**Re: Phase 1 Bedrock at The Trails by La Terra Development at 9300 Woodmont Ave. NW  
Erosion and Sediment Control Plan for Tracts 4 and 5 of the Trails Unit 3A  
Engineer's Stamp Date 4/4/24 (C09E011B)**

Based on the information in your submittal, received on 4/4/24, the above-referenced ESC Plan cannot be approved for a Work Order and Building Permit until the following comments are addressed.

BEDROCK
POND A6-1 & POND A6-2

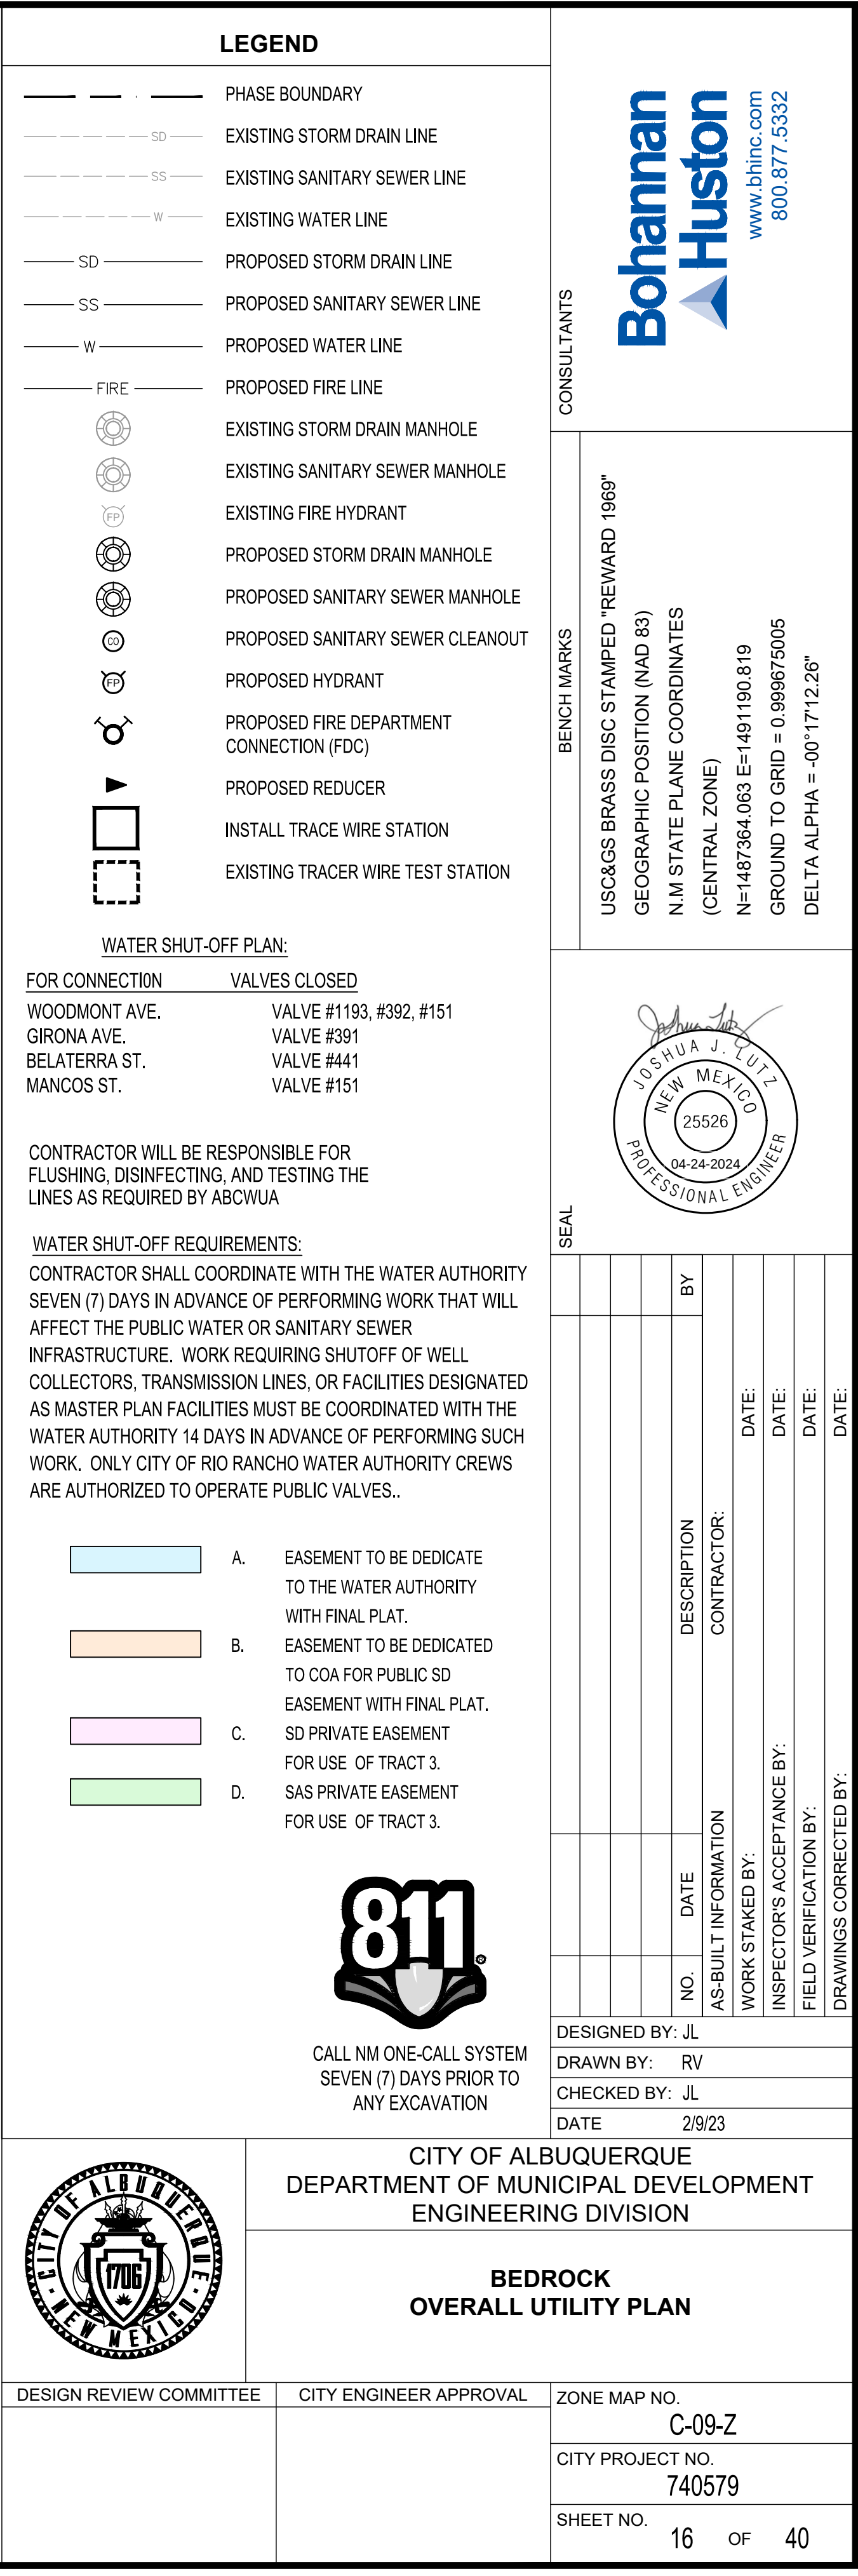
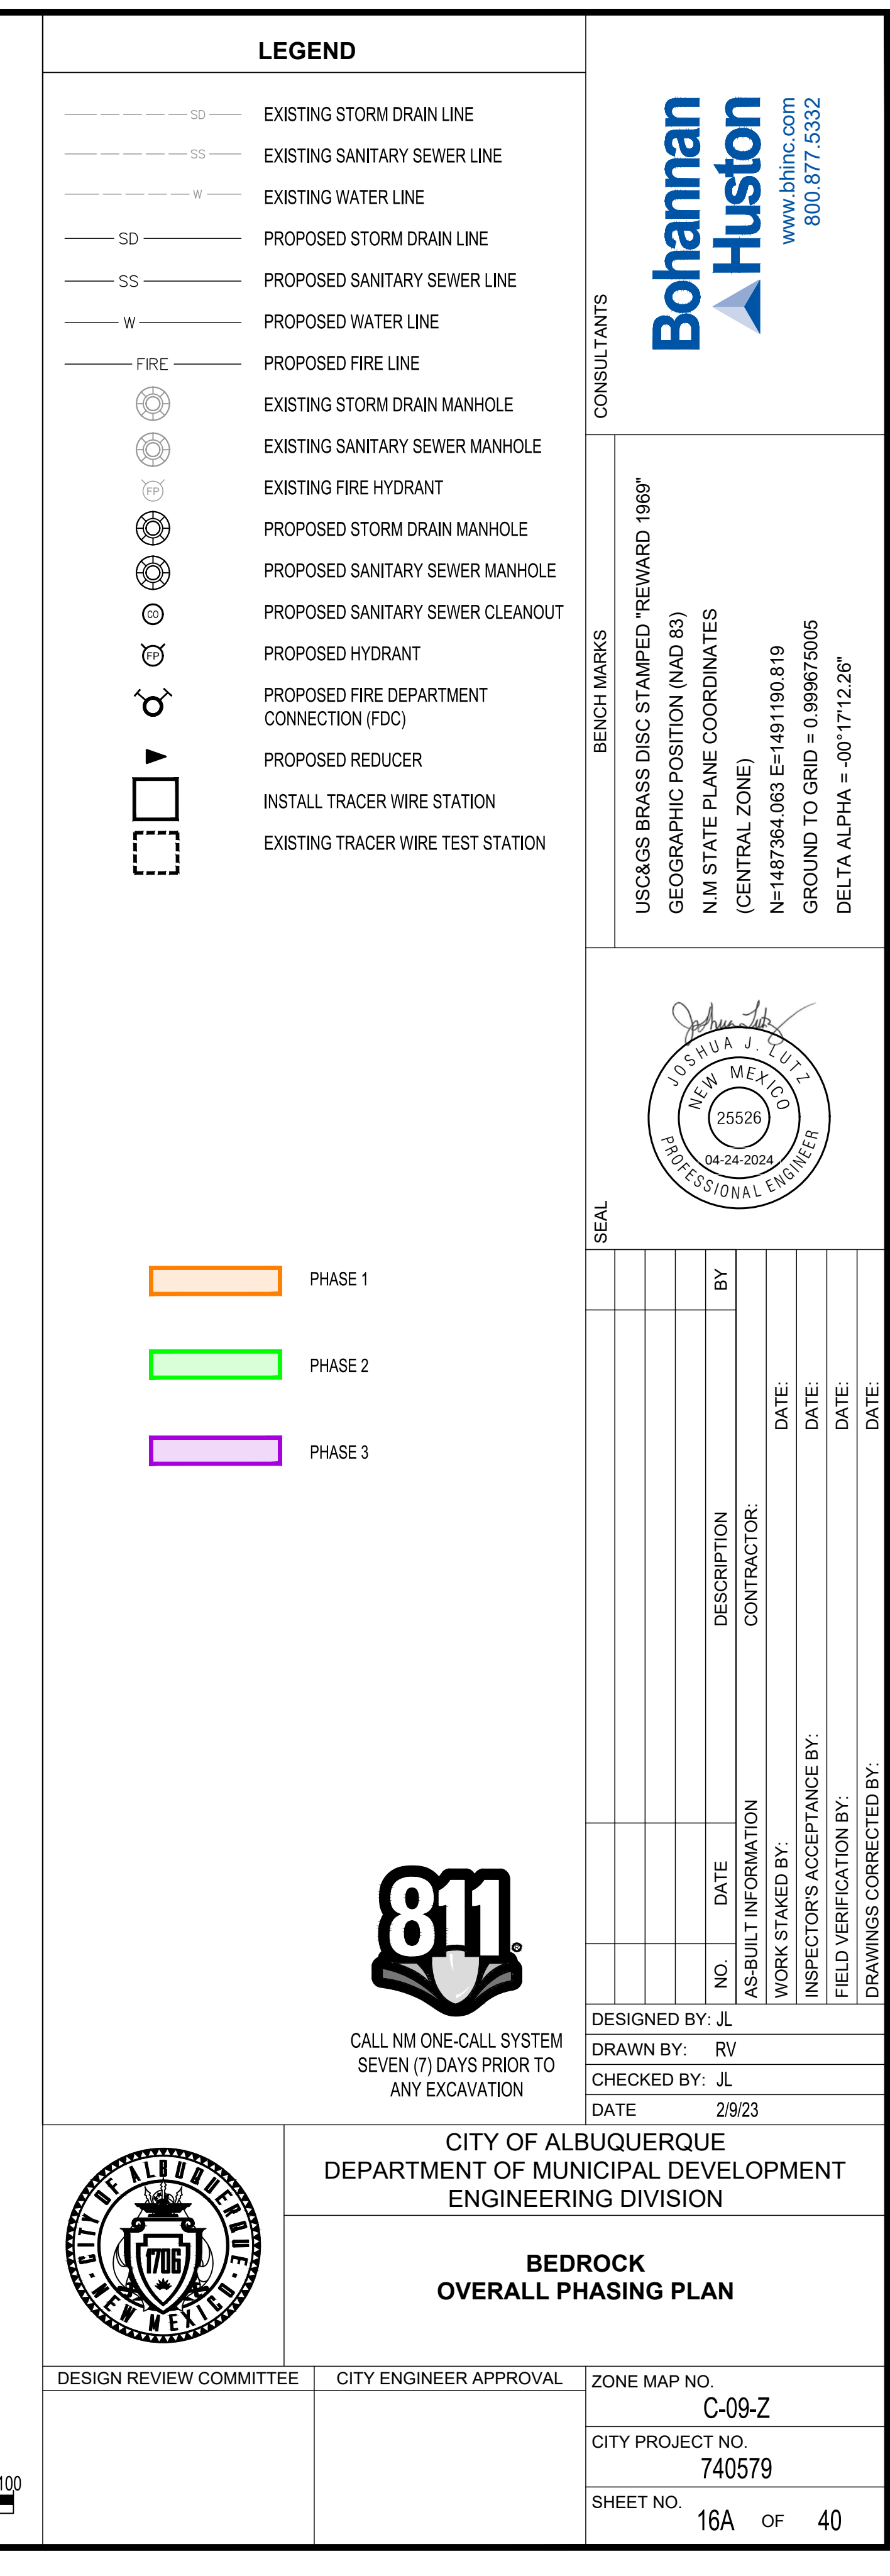
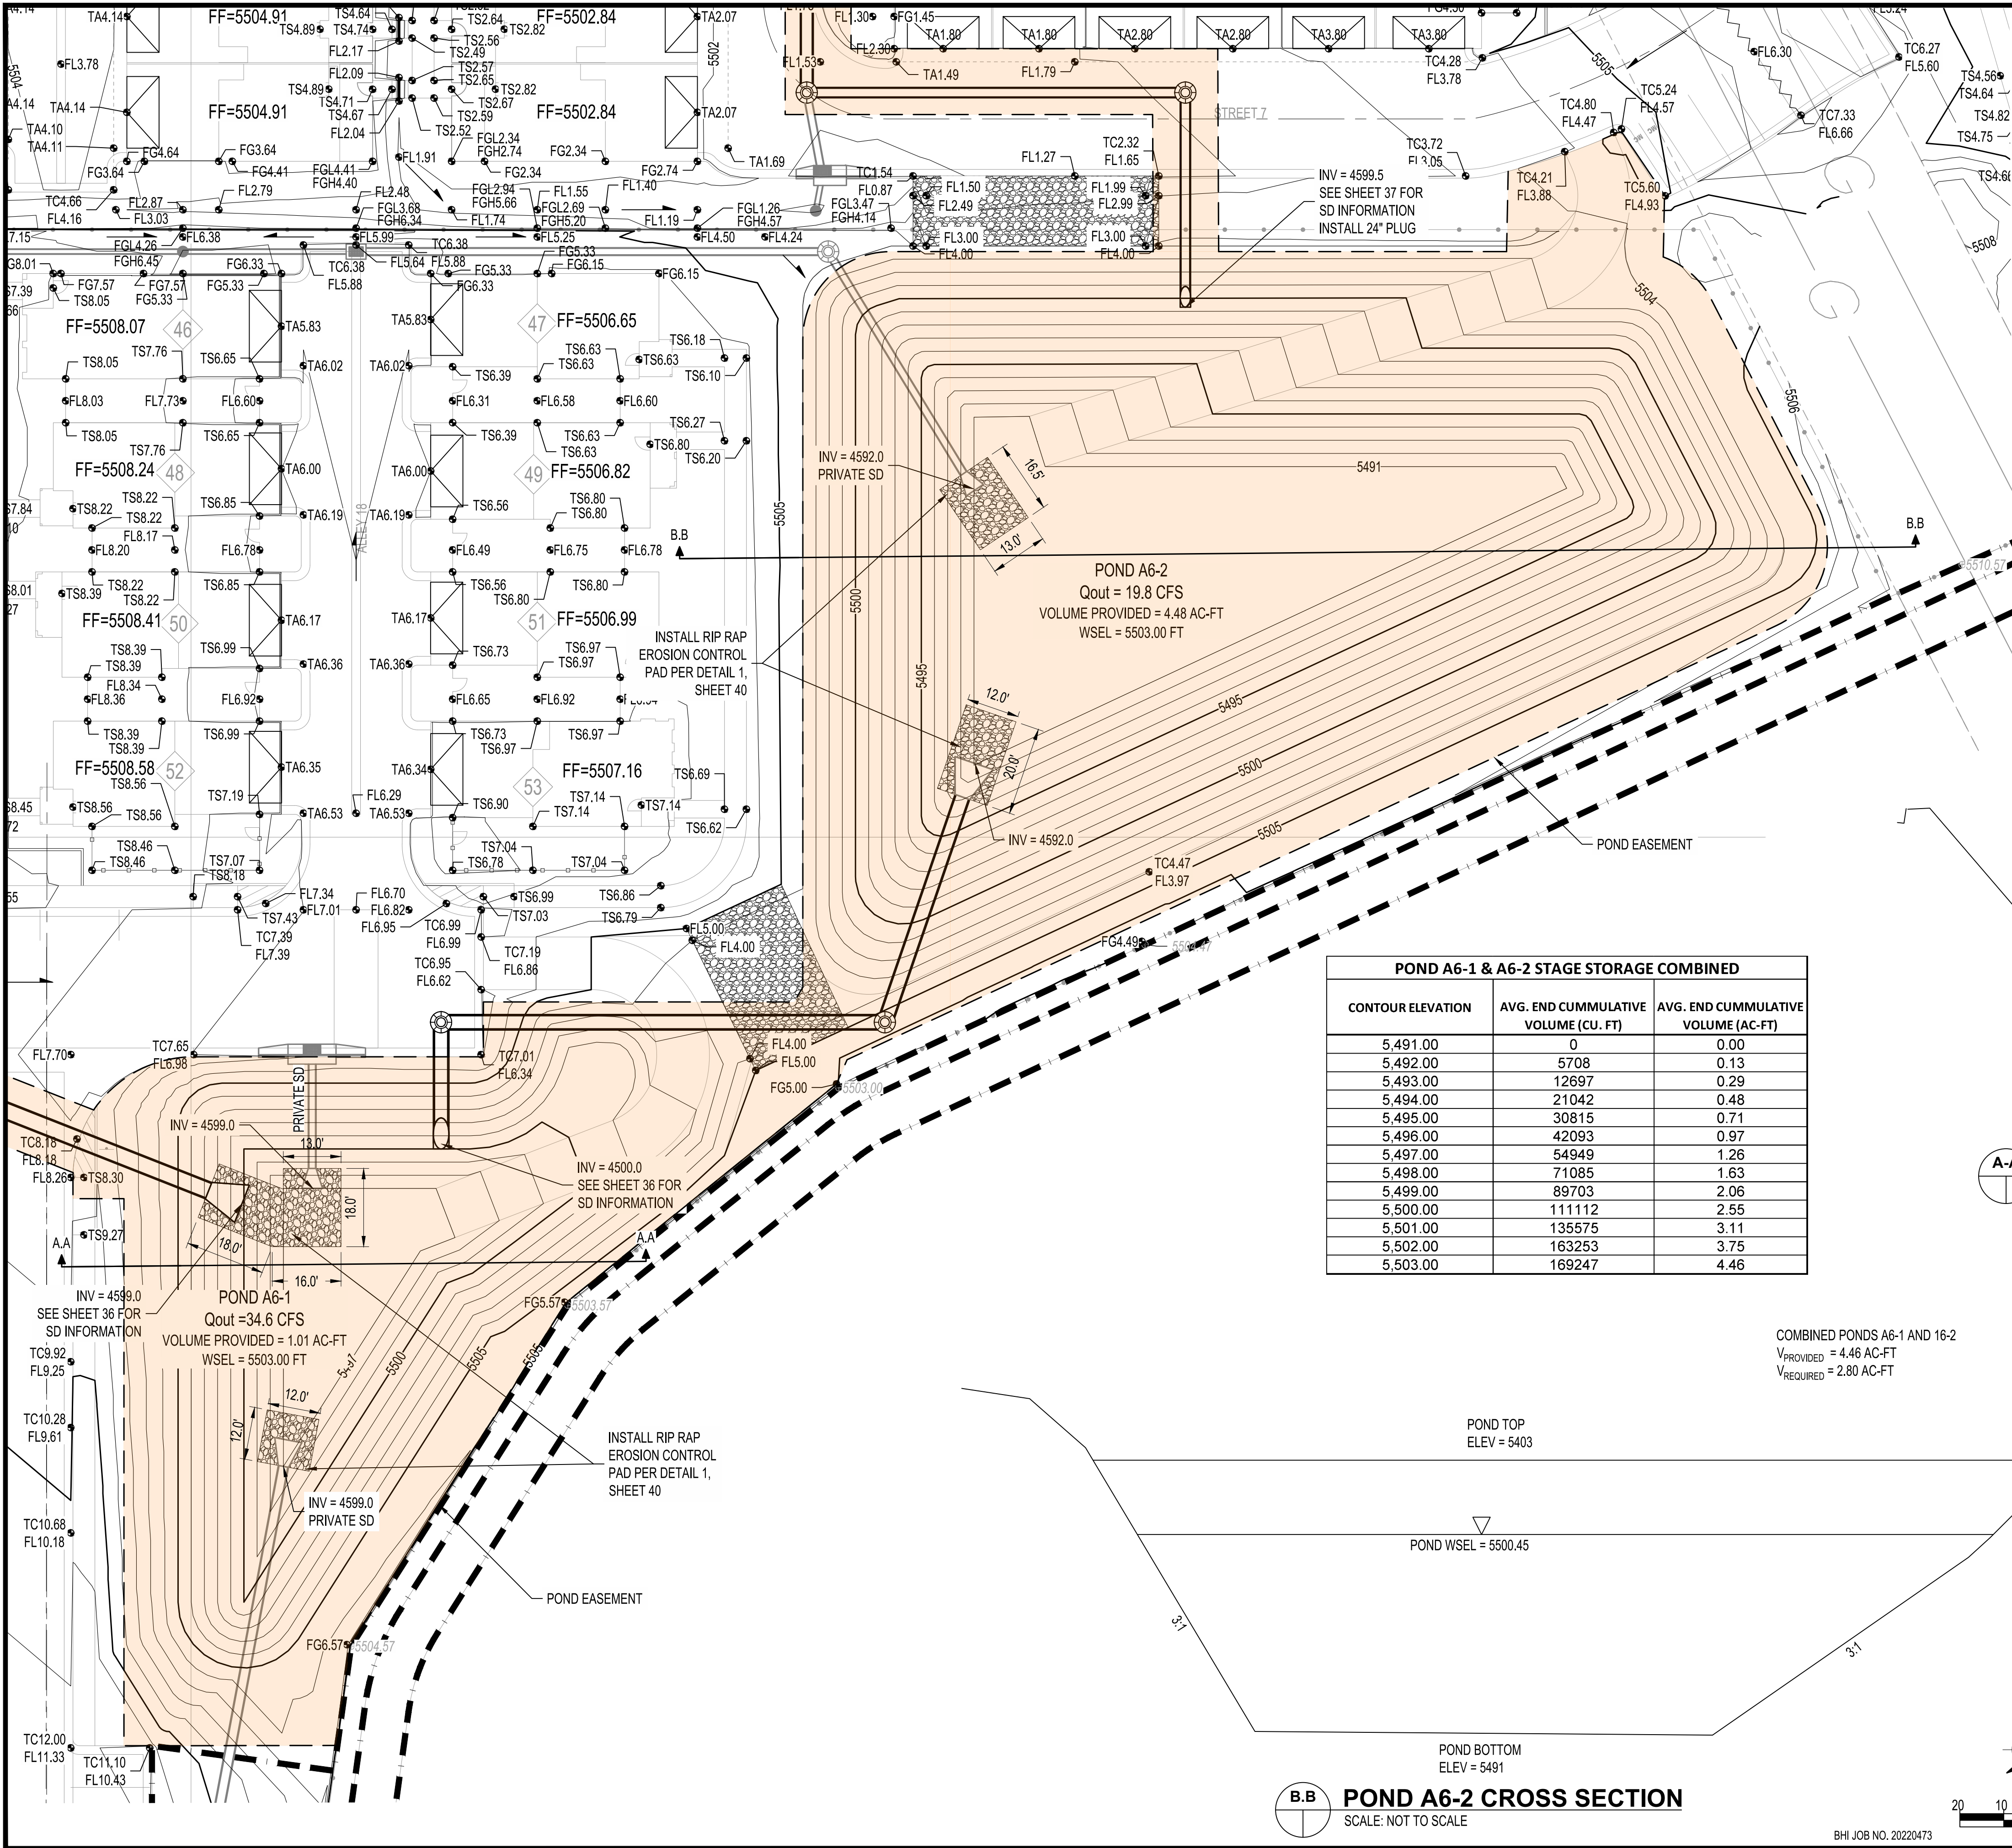
1. Page 2 of the infrastructure list says, "Side slopes and bottom of Ponds (A6-1, A6-2, and D-1) shall be stabilized per City Standard Specification 1013;" however, that specification isn't called out on any of the ESC Plan Sheets or the DRC Plan Sheets. The numerous references to the EPAs Final Stabilization Criteria CGP 2.2.14 must all be replaced with the City's more stringent specification in the DRC and ESC Plans. Correct the stabilization notes on the ESC Plan and on the Phase 1 Work Order sheets 39 and 40 to indicate Spec 1013 to be constructed after all other construction is complete in phases 1, 2, and 3.

2. Comment #3 and #4 in the letter dated 3/27/24 weren't properly addressed. Ponds D-1, A6-1, and A6-2 must remain sediment basins until construction and stabilization are complete in the entire drainage basin, including portions of phases 2 and 3. The volume calculations must include fully developed conditions for Basins 1, 2, 5, 6, and Offsite Basins A3. The design volume for temporary sediment basins is based on the entire area drained. Onsite erosion and sediment controls must be designed in accordance with good engineering practices, including applicable design specifications per CGP2.1.2. Please see the attached Virginia standard & specification for sediment traps (ST) and sediment basins (SB) as an example of how to design and maintain safe temporary water quality structures. Move the "Pond stabilization" from the fifth item under the "Bedrock Phase 1 Construction Sequencing" to the last item in Phase 3 on sheet ESC-2.
